Rezoning Transportation Analysis

Petition Number: 2022-120

Date	Description
12-29-22	First Review (PDM)

RZ1.00

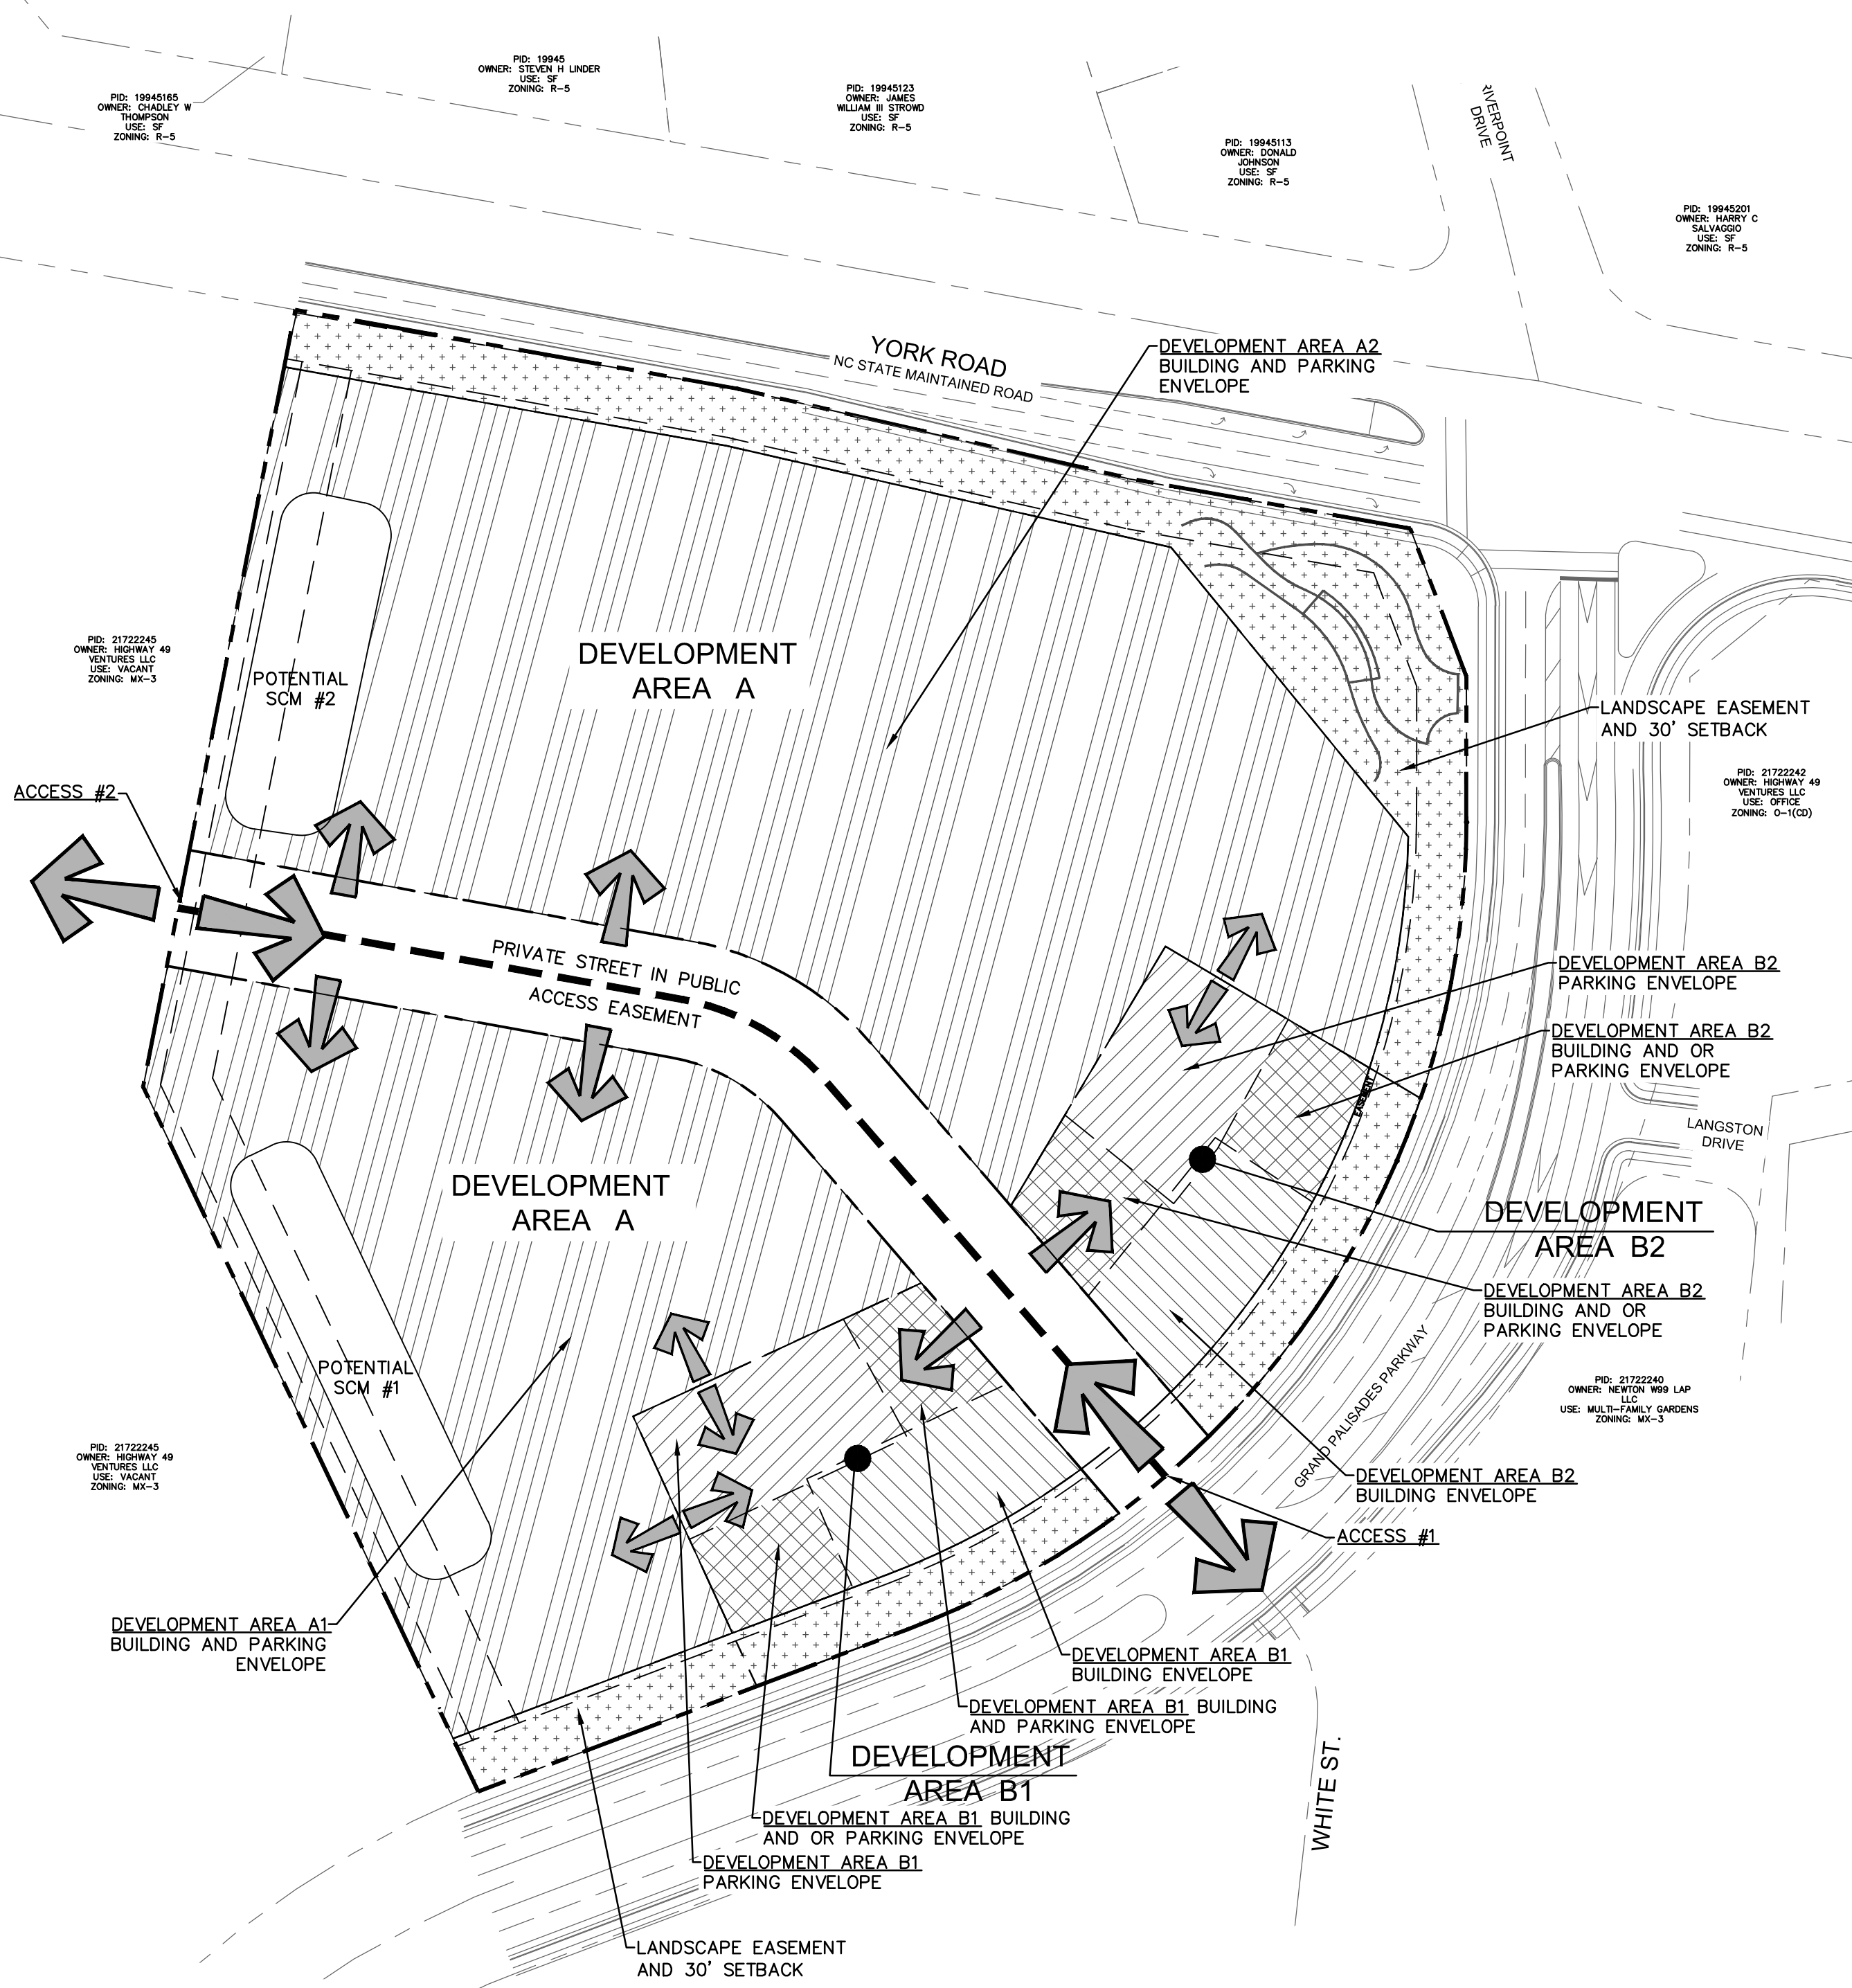
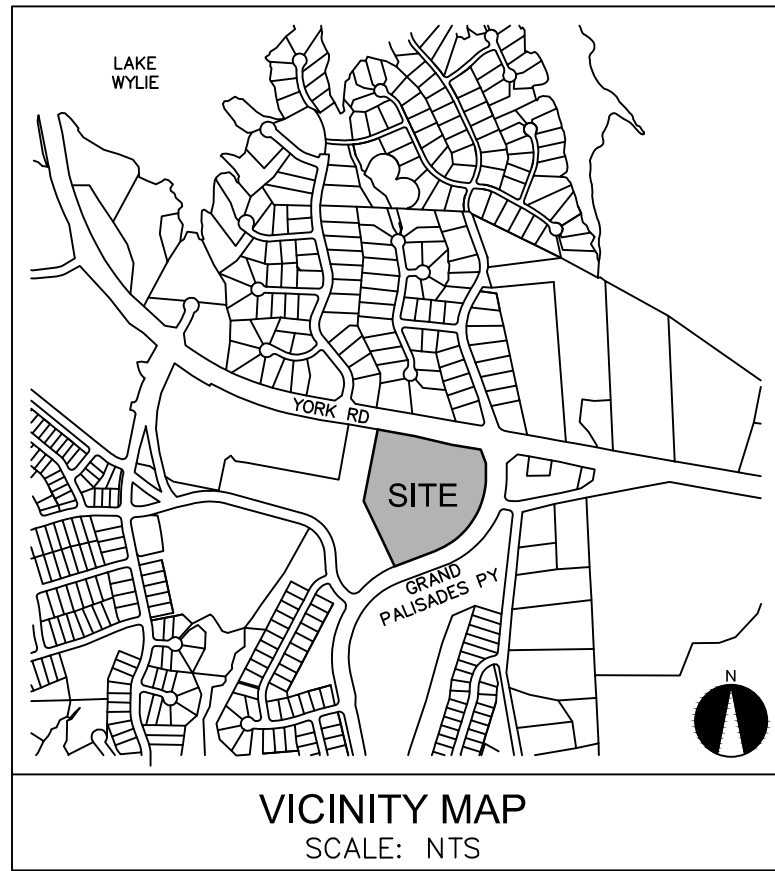
Label and dimension the curb and gutter from the centerline for each road on the site plan.

3. Revise site plan to dimension the right-of-way and back of curb on York Road and Grand Palisades Parkway.

4. Revise site plan and conditional note(s) to provide a left turn lane at the proposed site driveway with a minimum of 150ft of storage. In addition, restripe the existing left turn lane and median to remove the negative offset.

5. York Road Bike Facilities:
Revise site plan and conditional note(s) to commit to construct bicycle facilities by installing a 12' multi-use path on York Road to meet the Council-adopted Charlotte BIKES Policy. Multi-use paths maintained by the City shall meet ADA/PROWAG requirements. Dimension the 12' multi-use path and 8' planting strip.

6. Grand Palisades Parkway Bike Facilities:
Bike facilities should be provided on Grand Palisades Parkway to meet the Council-adopted Charlotte BIKES Policy. CDOT REQUESTS the petitioner replace the existing sidewalk with a 12' multi-use path and 8' planting strip on Grand Palisades Parkway to connect the multi-use path bike network from York Road to the existing multi-use path on Grand Palisades Parkway south of Tulloch Road. If multi-use path will not be provided on Grand Palisades Parkway, CDOT REQUESTS the petitioner revise site plan and conditional notes to commit to refreshing the existing bike lane markings on Grand Palisades Parkway as necessary. In addition, bike ramps should be provided near York Road and Tulloch to transition from bike lane to multi-use path.

7. CDOT REQUESTS the petitioner revise site plan and conditional notes to provide northbound dual lefts on Grand Palisades Parkway by restriping the existing painted median and modifying the traffic signal.

8. CDOT REQUESTS the petitioner revise site plan and conditional notes to modify the existing eastbound right turn lane on York Road to provide 250ft of full width storage.
